From: Nikki Matthews
Sent: Tuesday, 5 February 2019 11:16 AM
To: 'Taylor Richardson'
Cc: Phil Towler
Subject: SSD 7733 Penrith RRF - Comments on RTS
Attachments: Comment on RTS - Sydney Water - SSD 7733.pdf; Comment on RTS - DoI - SSD 7733.pdf; Comment on RTS - EPA - SSD 7733.pdf; Comment on RTS - OEH - SSD 7733.pdf; Comment on RTS - OEH Heritage - SSD 7733.pdf; Comment on RTS - Penrith Council - SSD 7733.pdf; Comment on RTS - RMS - SSD 7733.pdf

As just discussed over the phone, please see attached Agency comments on the Response to Submissions (RTS) for SSD 7733. These will also be visible on the Department's Major Projects website shortly.

Drawing Title
PROPOSED SITE PLAN

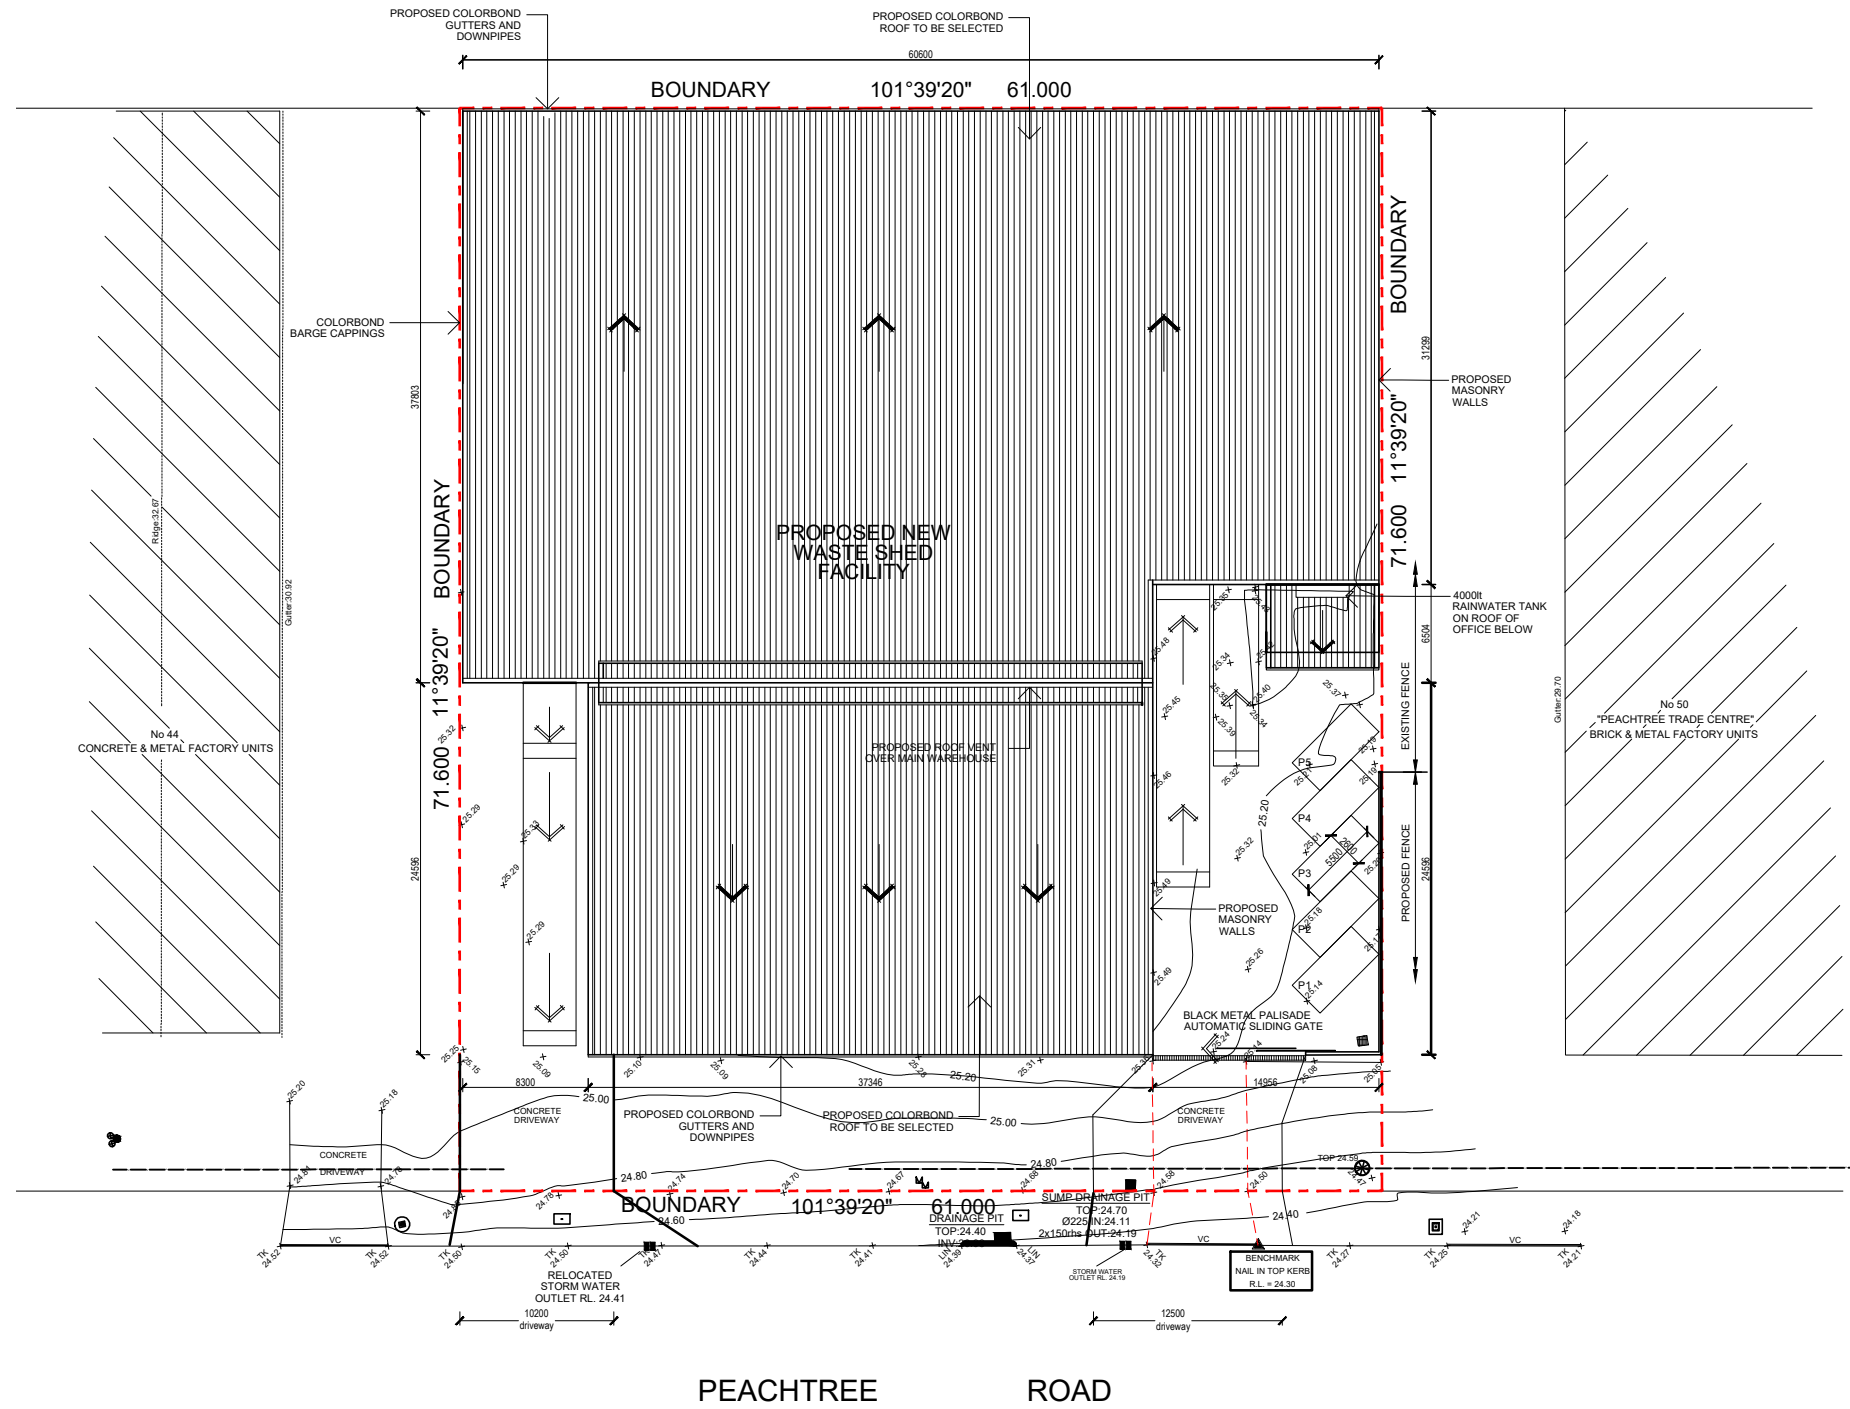
The Department's request for RTS required the Applicant to clearly identify the storage location of dangerous goods and hazardous materials. The Department notes this is described in section 4.1.10 (ii) of the RTS however this area should also be clearly identified on a site plan.
